TANKERSLEY PARISH COUNCIL

Planning Application - 2026/0034 - Outline application for the erection of one dwelling with details of access and layout (other matters reserved).

Figure 2.1 Junction of Pilley Green with Carr Lane

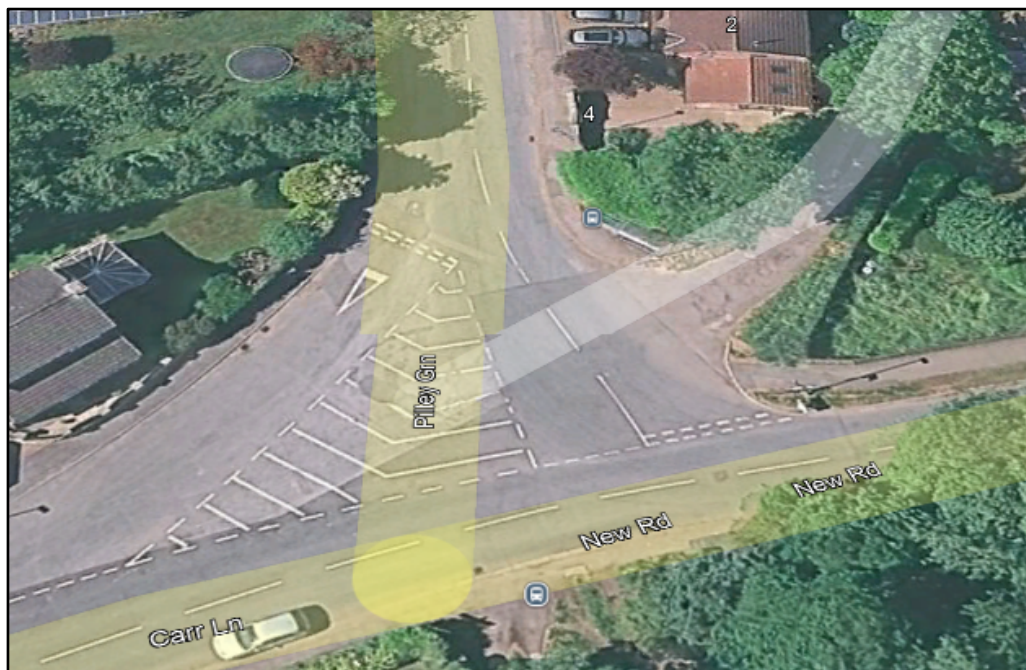
3. Further observation regarding traffic concerns is that the image on page 6 of the Highways Statement is not relevant to the application as this image is of the junction of Carr Lane/Pilley Green which is located no where near the application site.
4. The Parish Council request that Barnsley Council's inhouse highways department comment on the application and scrutinise the statements made by the applicant to ensure compliance with relevant statutory obligations
